From: Nat Belderson [REDACTED]
Sent: 22 January 2020 12:18
To: Michael Eastham <Michael.Eastham@arun.gov.uk>
Subject: RE: A/122/19/OUT - Land off Arundel Road, Angmering - Development Framework Plan

Please find attached the further revised layout plan for A/122/19/OUT.

The Development Framework Plan shows the Site boundary, the means of access into the Site, the areas of retained and new landscaping and the location and extent of the proposed land uses, including the amount of built development.

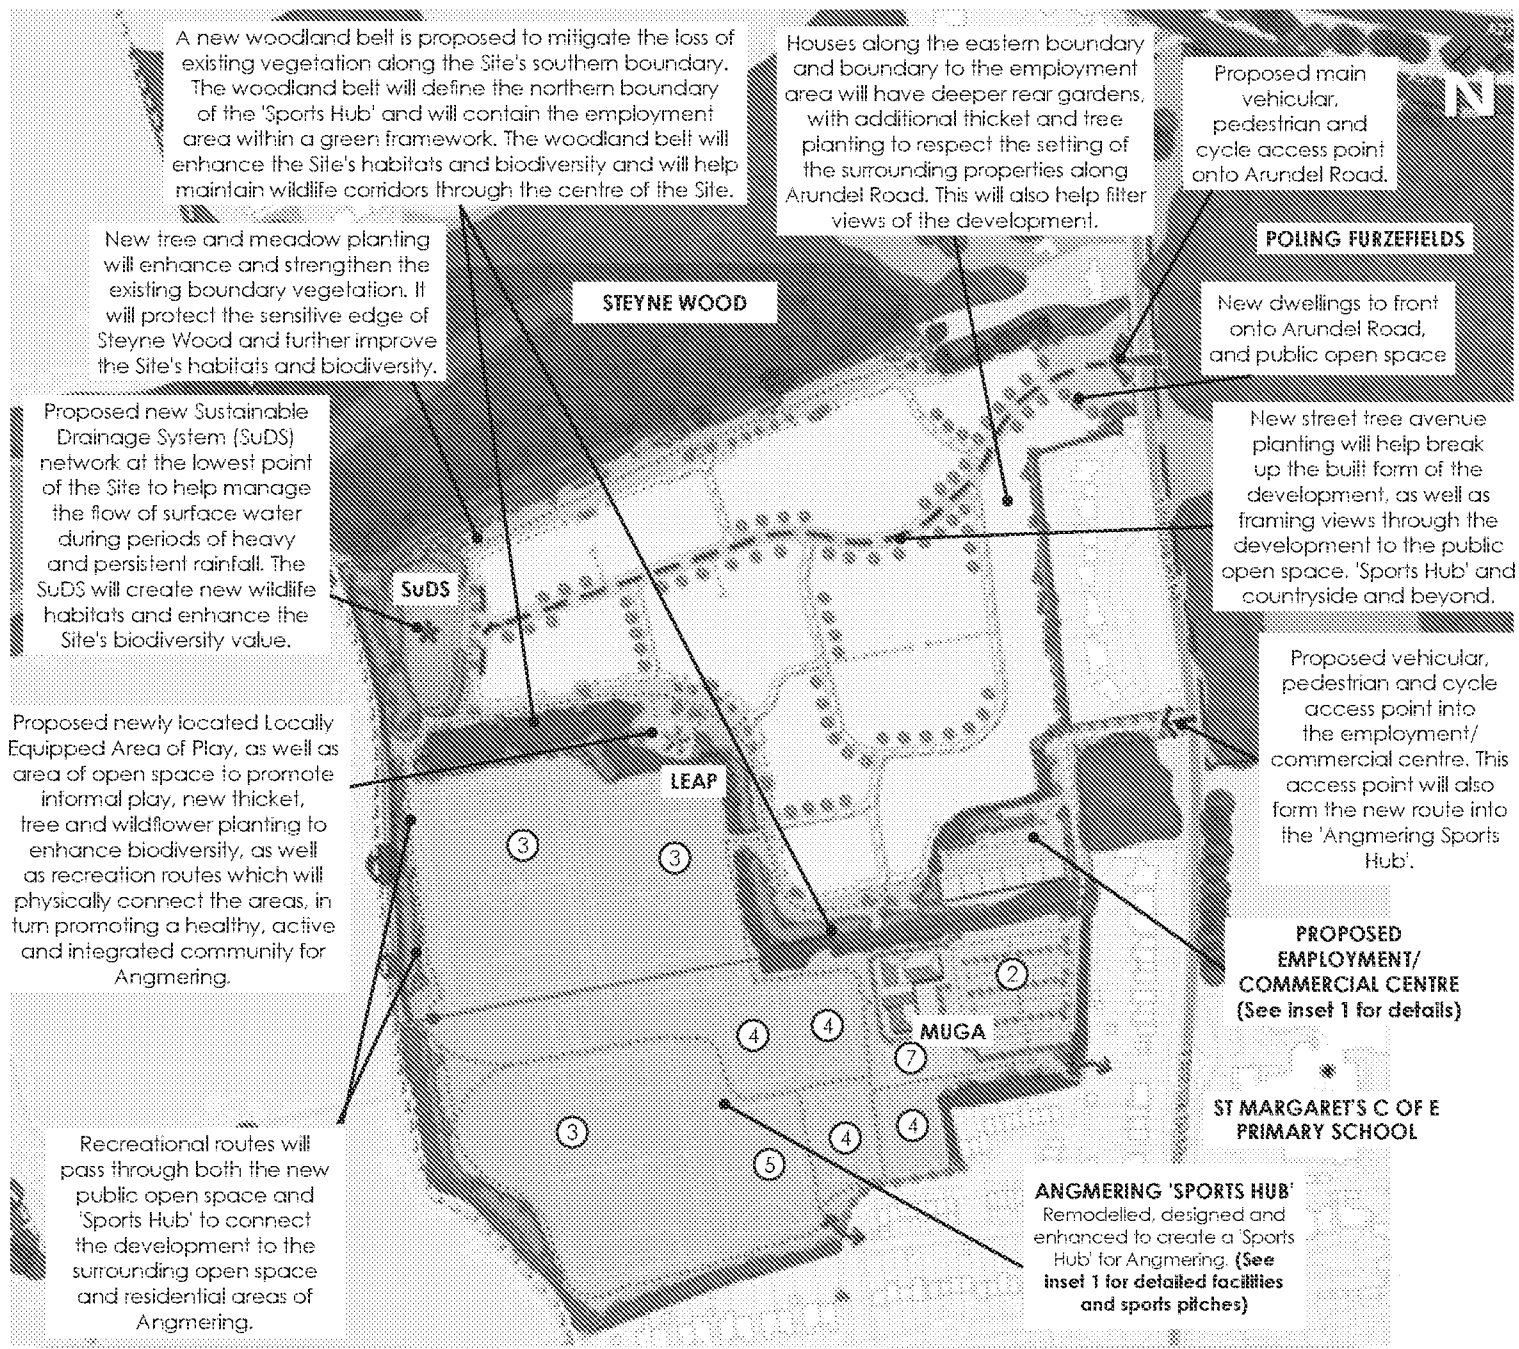
I note the reasoning given below why a link cannot be provided to the footpath on the western boundary. This is disappointing (a link south to Angmering village is not relevant to us as it is northwards connection to the Downs that we are interested in), and we'd wish to maintain a desire for such a link. However, I think you have probably pursued this as far as you can and lack of such a link, though regrettable, should NOT be taken as a formal objection from the SDNPA.

The revised layout plan refers to the foot/cycleway being amended, but the SDNPA is seeking confirmation that there would be a connection with the PRow that follows the western border of the site and/or a pedestrian/cycle route alongside Arundel Road. A connection with the PRow along the western boundary would be achievable, but at the moment appears to be prevented by new hedgerow planting.

Thanks for sight of this latest revision. I note that it refers to the foot/cycleway being amended, but I'm afraid I haven't been able to identify how this differs from the previous revision (Rev D)! The key point I'd be seeking for any such amendments would be confirmation that there would be a connection with the PRow that follows the western border of the site and/or a pedestrian/cycle route alongside Arundel Road. The former would seem very simple to provide, but at the moment appears to be prevented by new hedgerow planting.

The previous iteration of the DFP showed a footpath only. We agreed this would be shown as a footpath and cycleway and noted that it would link into the wider Public Right of Way network. We can't however form the final connection point onto the PRow as this point of connection falls outside our land ownership and in the Palmer Road recreation ground – the connection is reliant on the sports pitch/hub proposals being implemented and part of our land gifting. A footpath cannot connect from our Western boundary directly as there is an existing hedgerow that defines our legal boundary ownership, with a ditch in third-party ownership before the PRow can be reached. However, the £550,000 contribution towards a cycle route to Angmering village centre appears to address this concern directly.
